Swan Rd

**DISAPPROVED**  
Plan Review  
04/07/2022 2:35:51 PM  
*dsdarchuleta*  
EPC Planning & Community  
Development Department

6 Site Plan

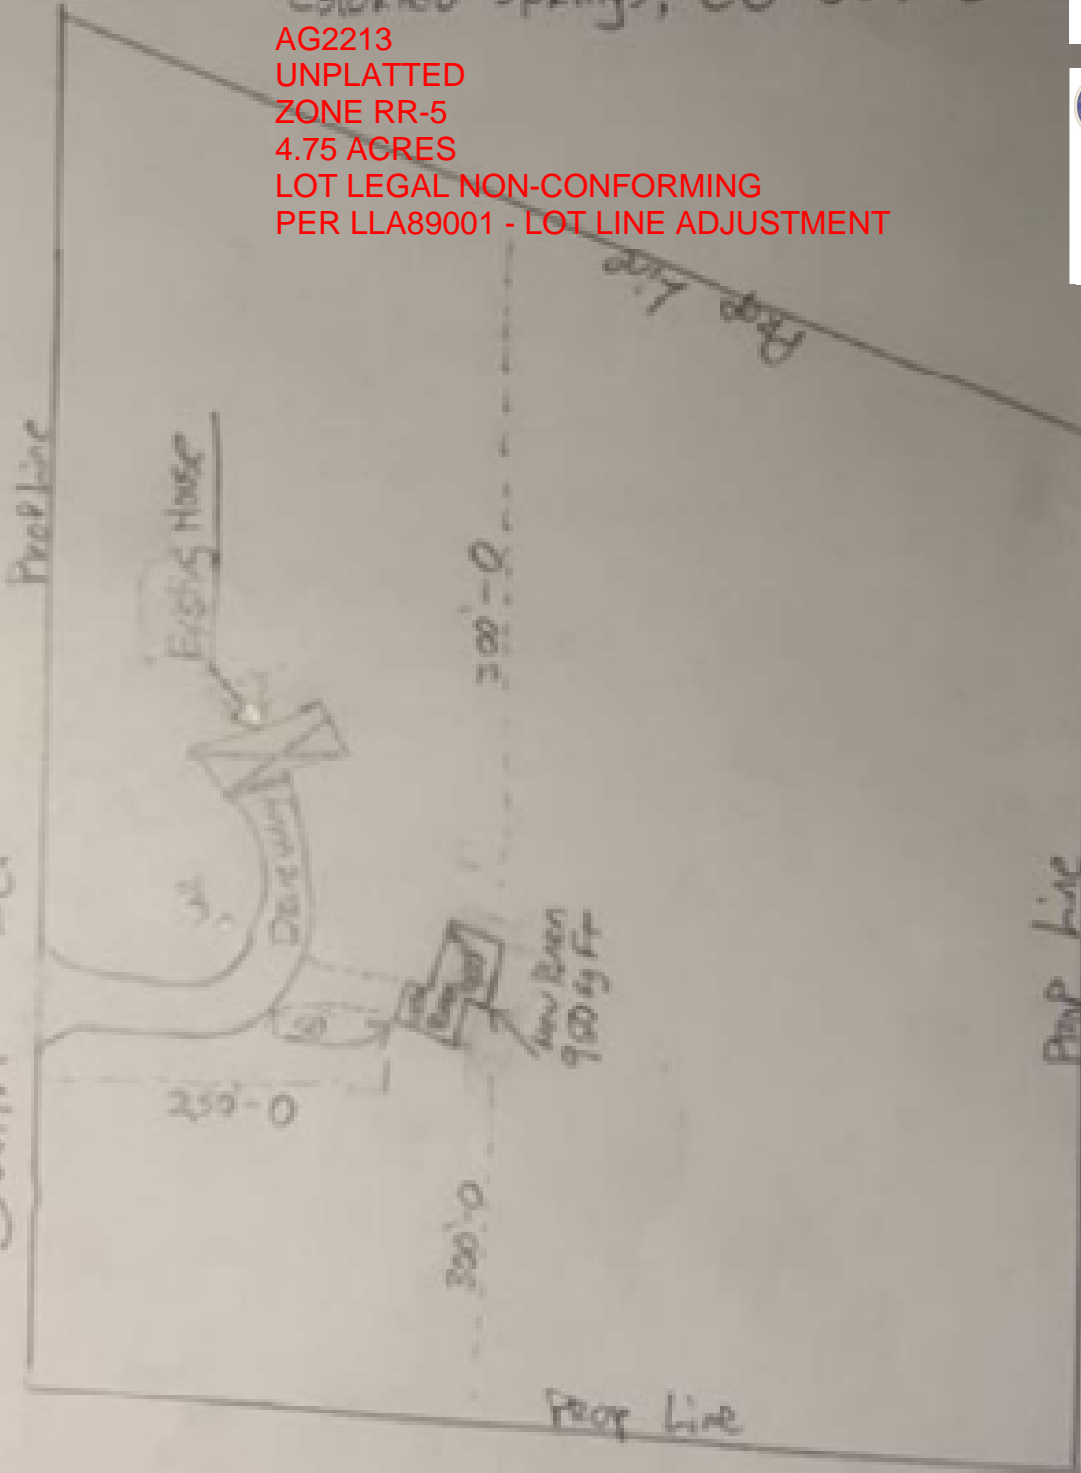
- 1) SHOW THE HOUSE ADDRESS
- 2) DRIVEWAY ACCESS MUST BE SHOWN
- 3) IDENTIFY THE NEW STRUCTURE
- 4) SHOW THE STRUCTURE DIMENSIONS OR SQUARE FOOTAGE
